3 July, 2023

**RE: PROPOSED RESIDENTIAL AGED CARE FACILITY,
59-67 KARNE STREET, NARWEE**

2. This addendum traffic document has been prepared to support the response to submissions report for the Narwee Parklands Care Community State Significant Development Application (SSD-45024776) located at 59-67 Karne Street North, Narwee. The NSW Department of Planning and Environment (DPE) placed the Environmental Impact Statement and the accompanying technical documentation on public exhibition from 14 February 2023 until 13 March 2023. During the exhibition, a total of 23 submissions were received in response to the public exhibition of the EIS. These included submissions made by state and local government agencies as well as the general public.

7.3m AMBULANCE VEHICLE
SWEPT PATHS

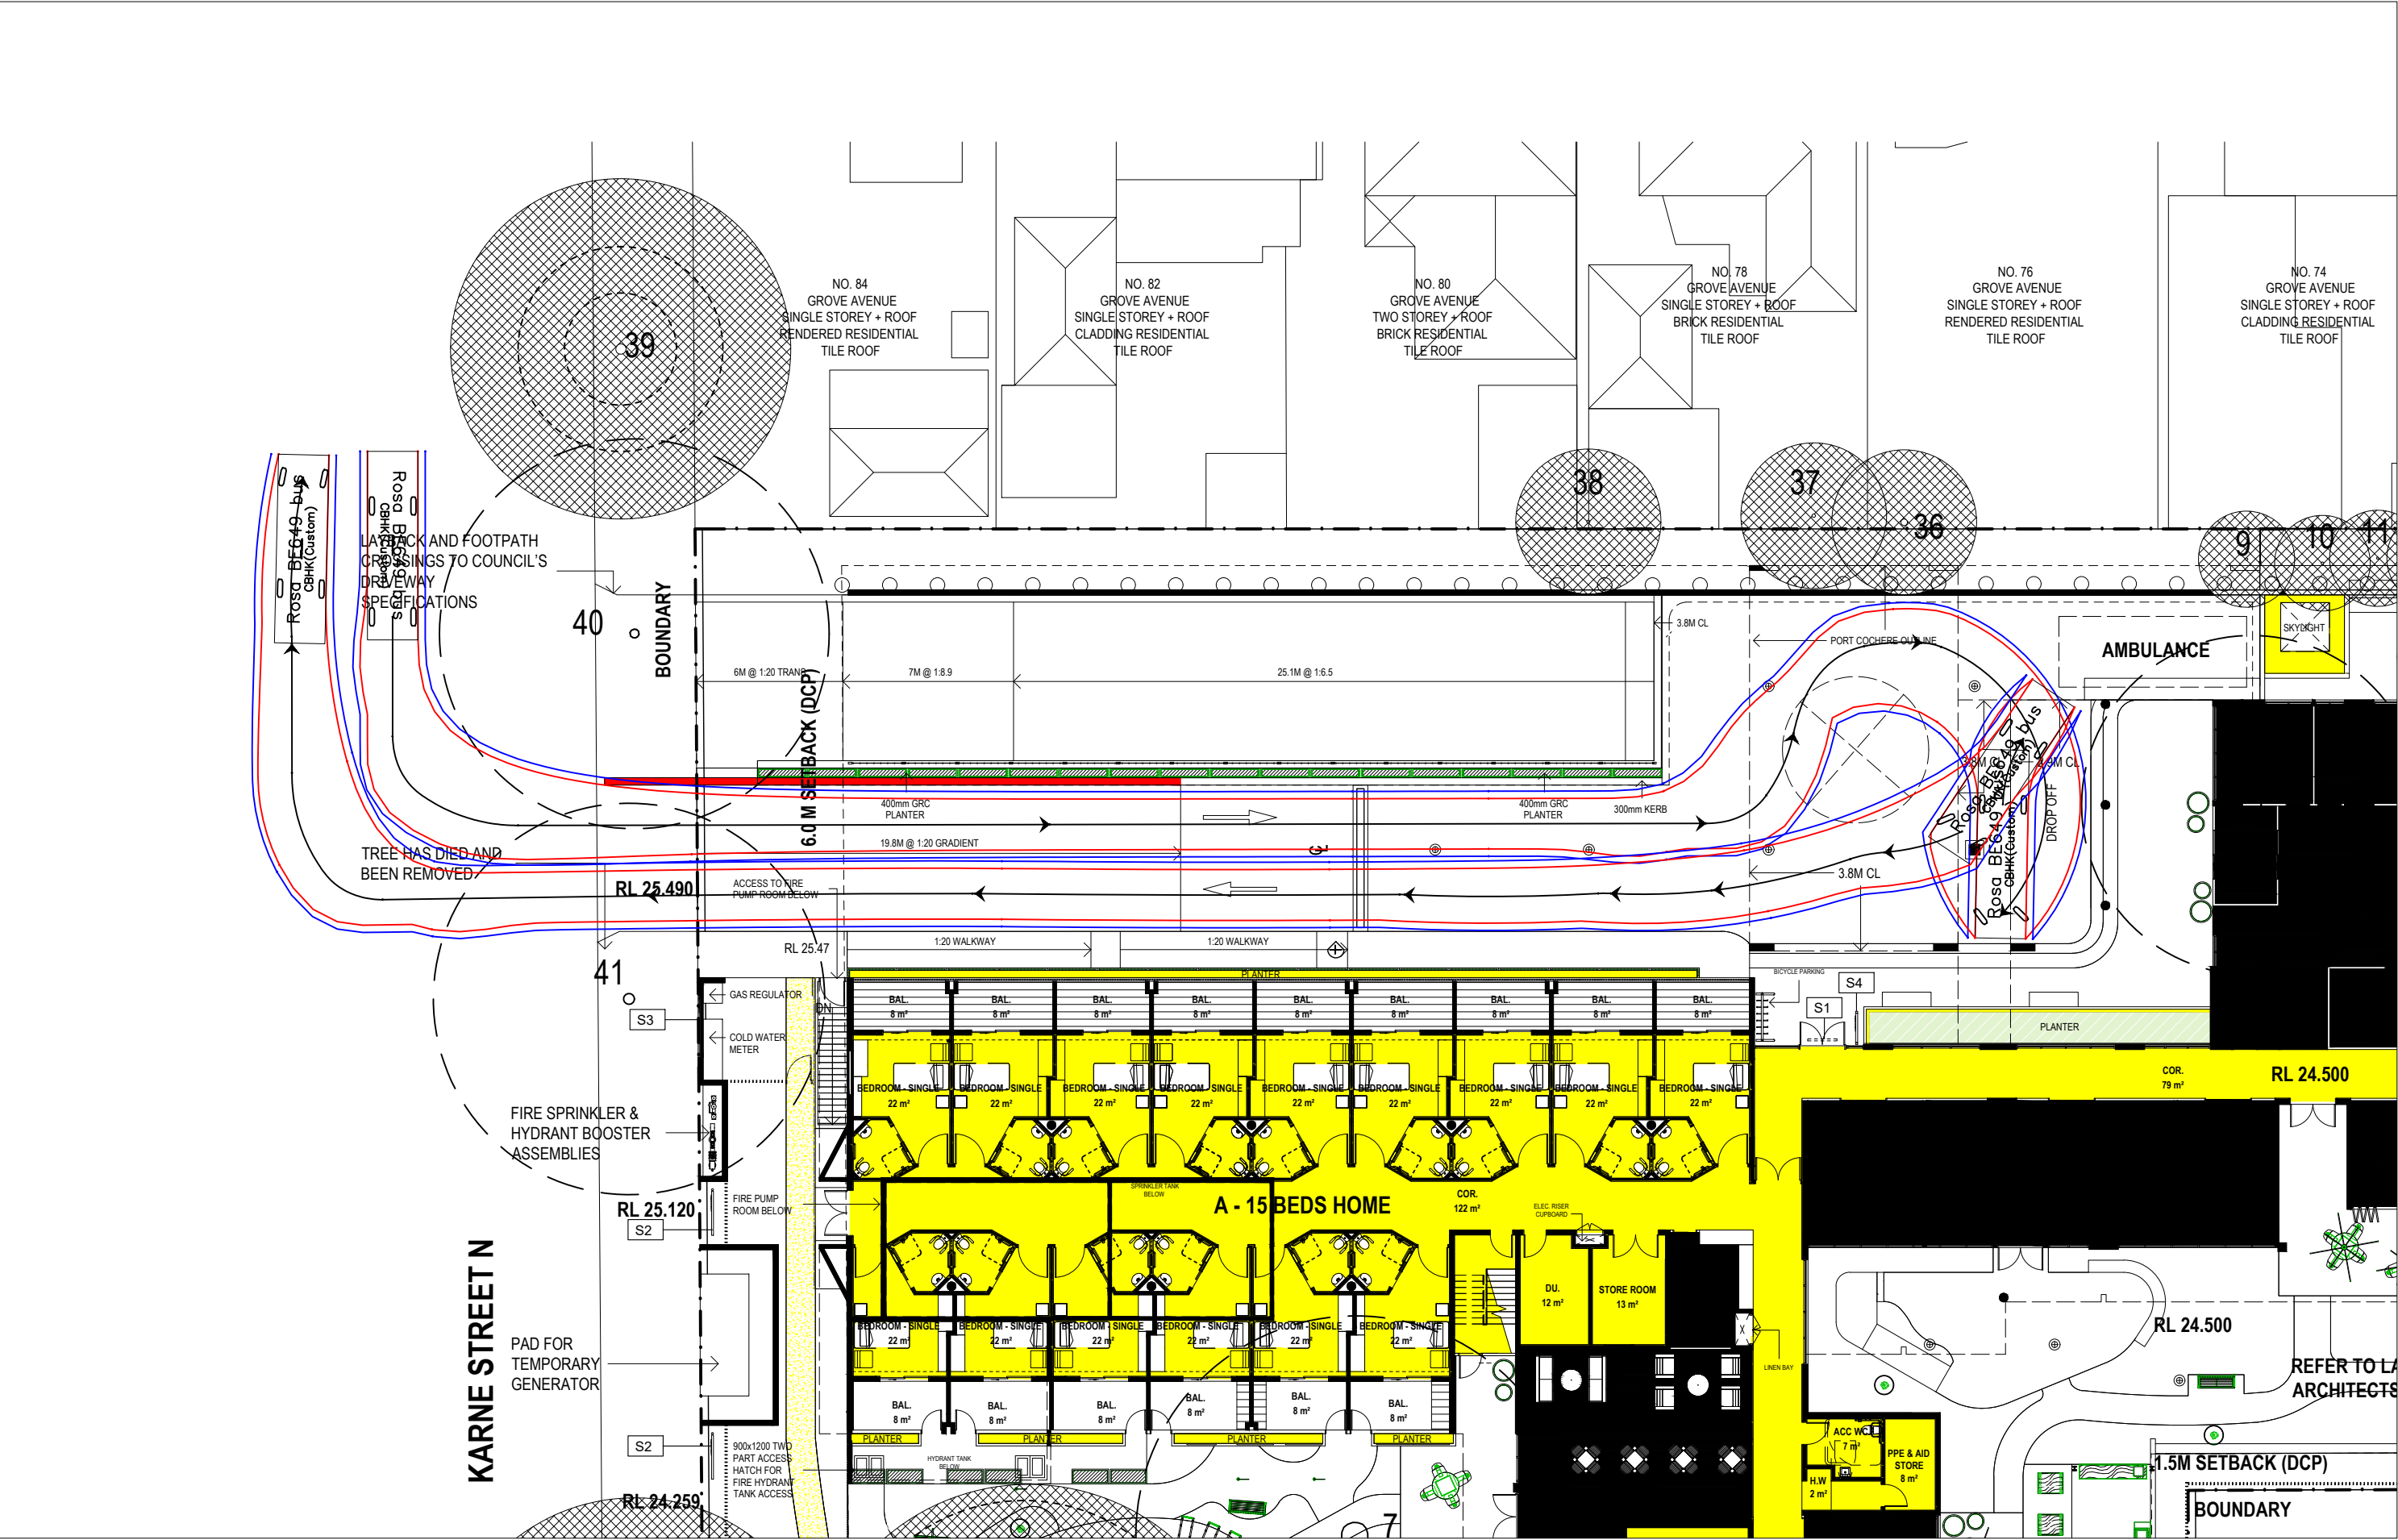
- (d) *Further consideration is to be given towards the ambulance turning circle in accordance with the relevant standards in Vehicle Access Specifications – NSW Ambulance, noting the sensitive use and increased potential for ambulance attendance to the site.*

11. The ambulance swept paths in our previous report (Figure A3) are for a 7.3 metre long ambulance, the longest vehicle used by NSW Ambulance.
 - (e) *The architectural plans must be amended to accurately identify the parking spaces breakdown including allocating for visitors and staff.*

9.9m GARBAGE TRUCK
SWEPT PATHS

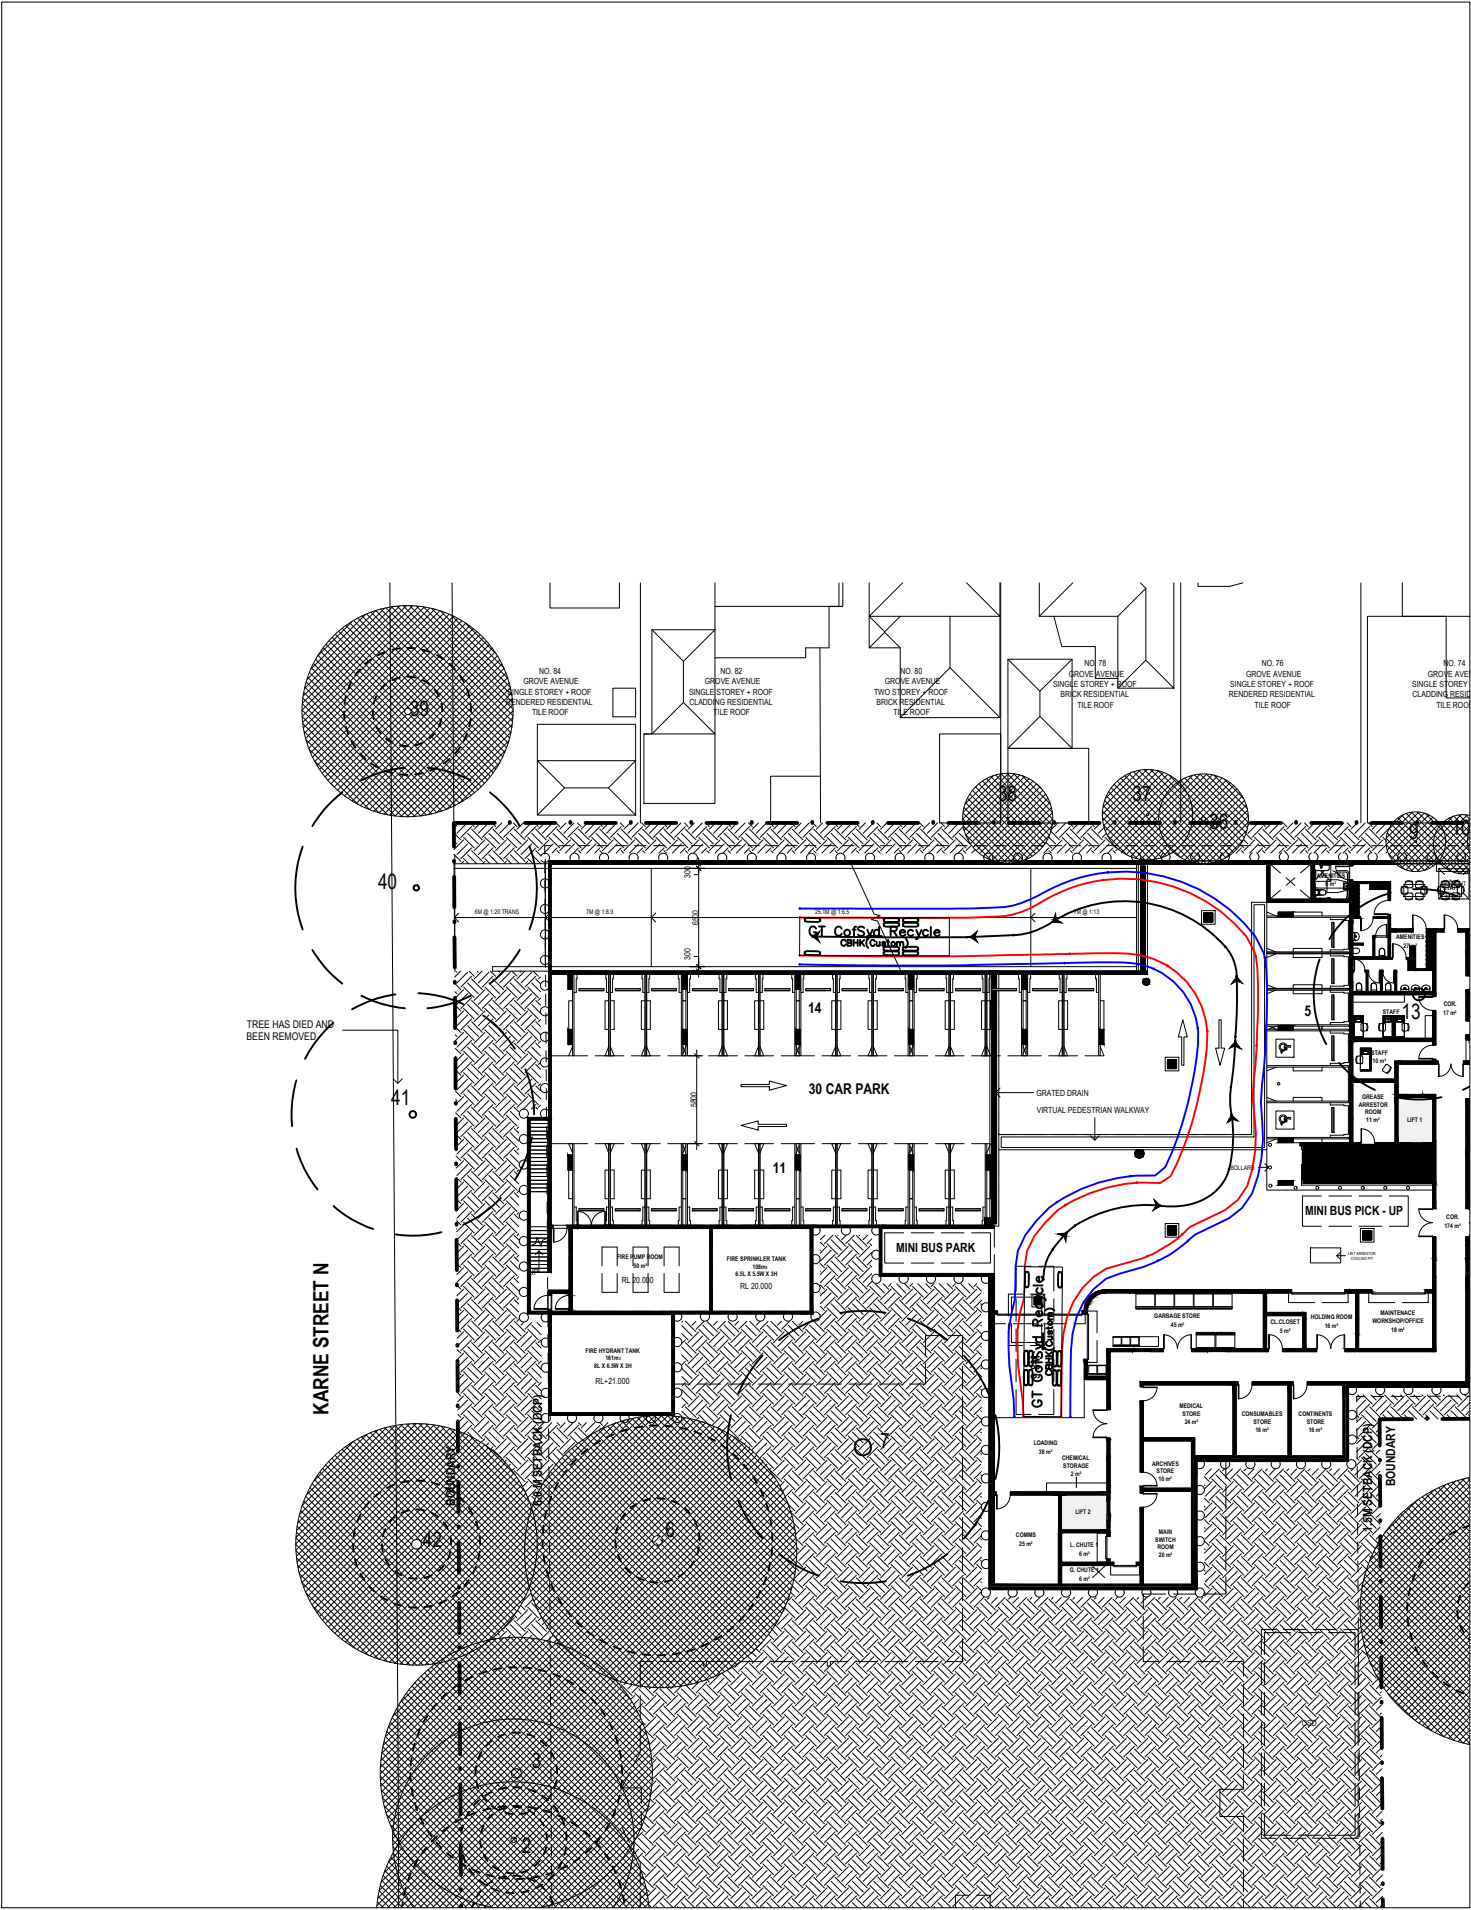
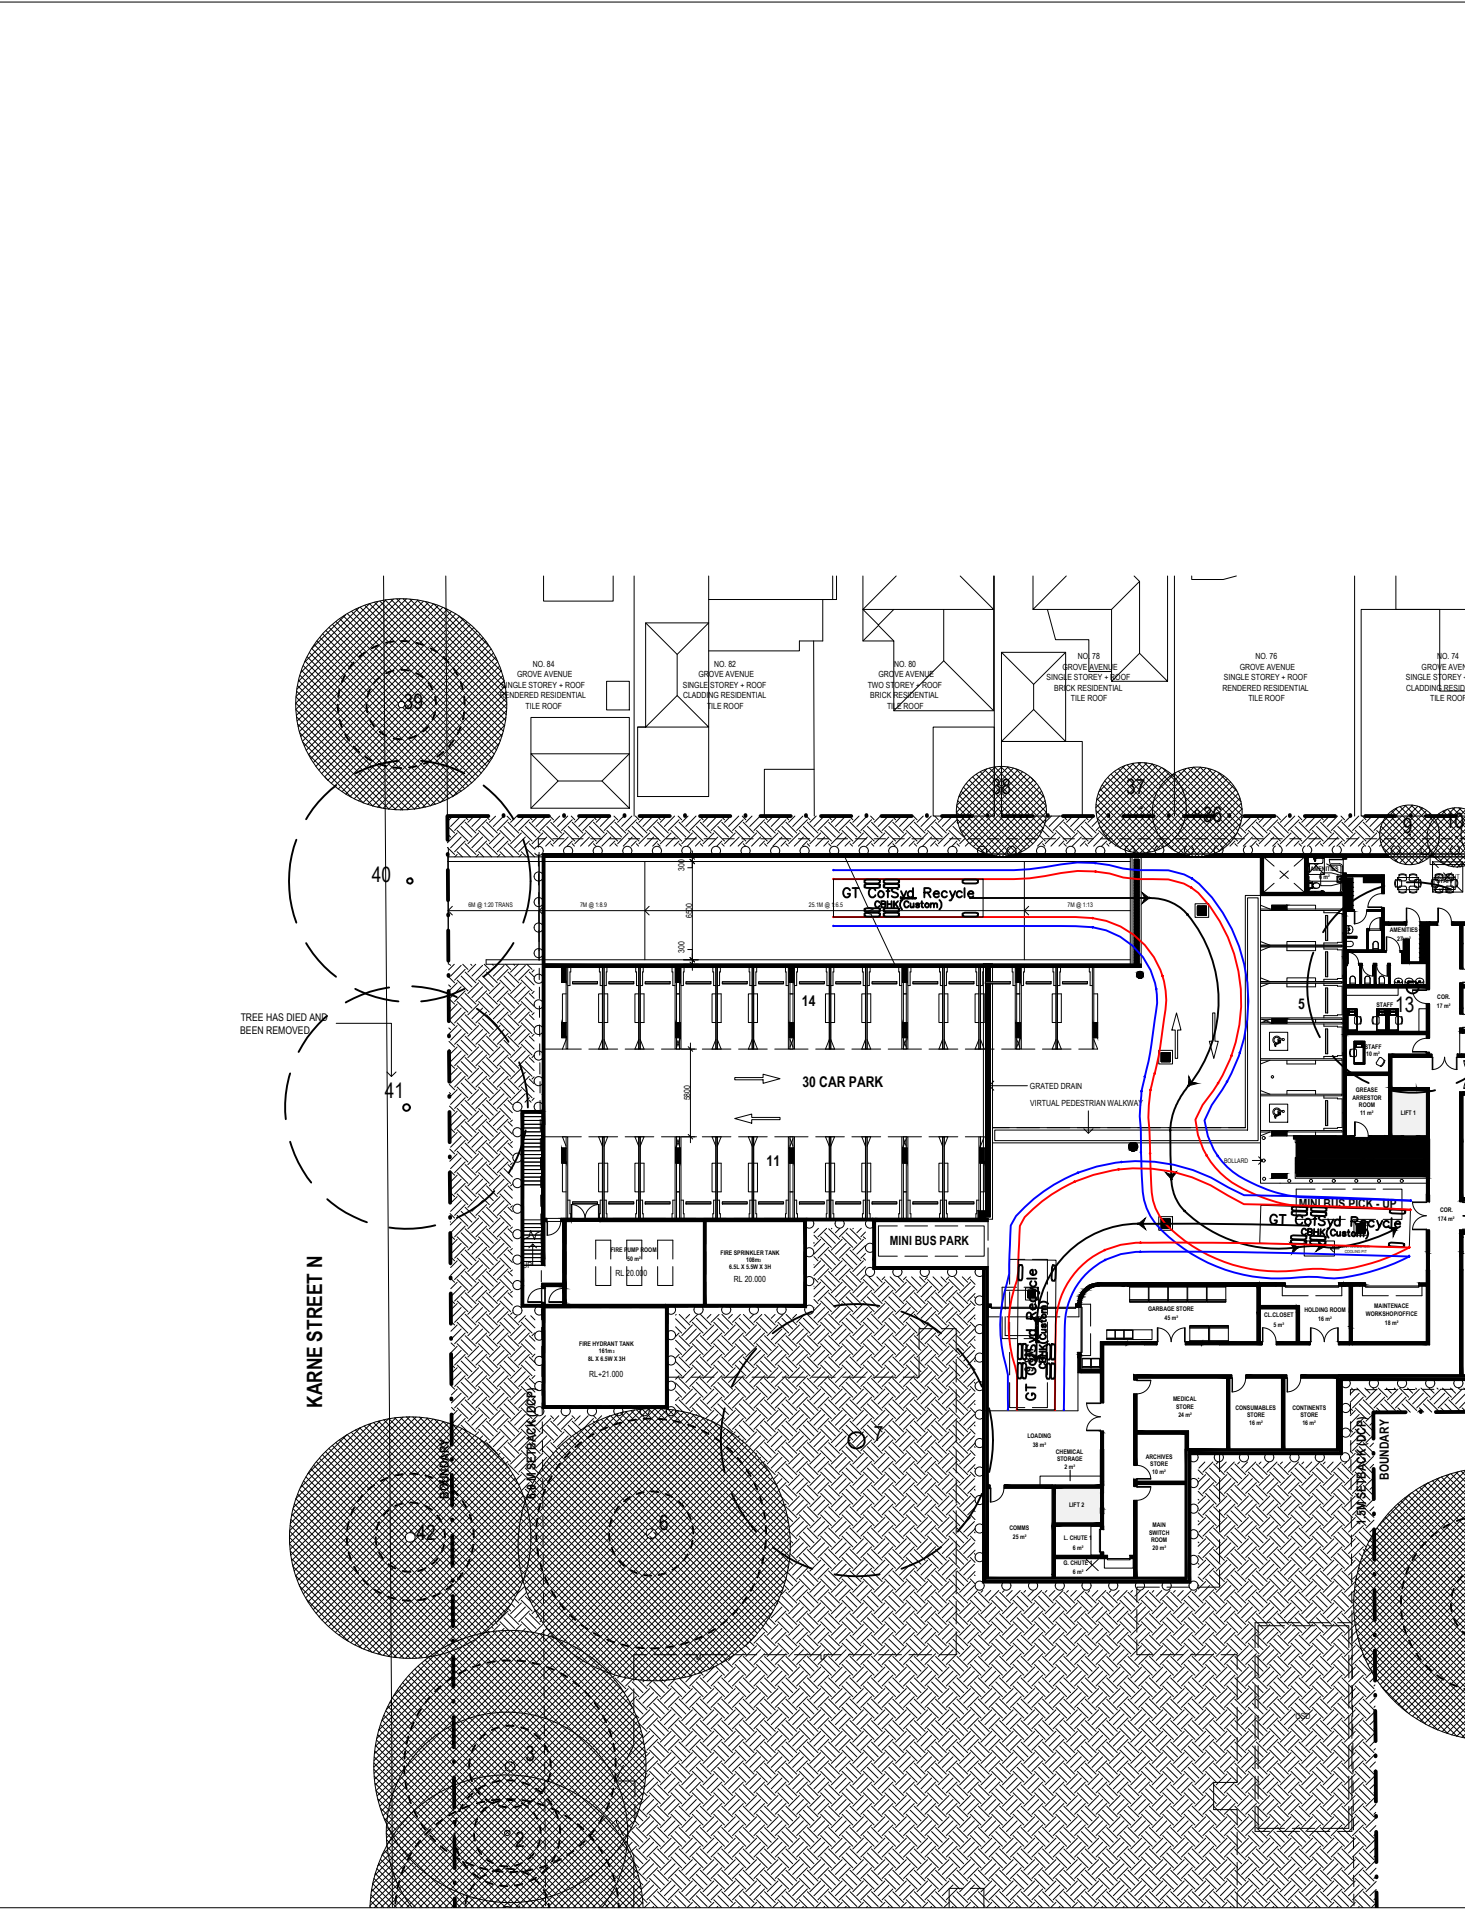
5. *Amend the plans to demonstrate compliance with AS2890.2 and provide swept paths for a Heavy Rigid Vehicle*

- *The location of the bin collection point must allow for a Heavy Rigid Vehicle (HRV) to enter and exit in a forward direction. All movements must comply with the Australian Standard AS2890.2*
- *Demonstrate a HRV can service the site without hindering traffic flow (i.e., the full length of the HRV must be contained within the loading bay while still allowing a 2-metre rear clearance and not be located within the driveway area).*
- *Headroom allowances compliant with AS2890.2 for the entire travel path.*
- *Swept paths need to demonstrate HRV movements in addition to the provided B85 vehicle.*

4. As noted in our previous report, a loading area will be provided in the basement, suitable for rigid trucks ranging in size up to 10 metres long, for garbage collection and deliveries. 3.9 metres height clearance will be provided in all areas used by service vehicles (suitable for the largest service vehicle used by the operator, for garbage collection). Service vehicles will be able to enter and exit the site in a forward direction. Vehicle swept paths are provided in Appendix A of our previous report.

5. The applicant uses contract waste collection and delivery vehicles which will be accommodated in the proposed loading bay. Larger vehicles, including 12.5 metre heavy rigid vehicles identified by the council, are not proposed for the development. There is therefore not a requirement to accommodate them.
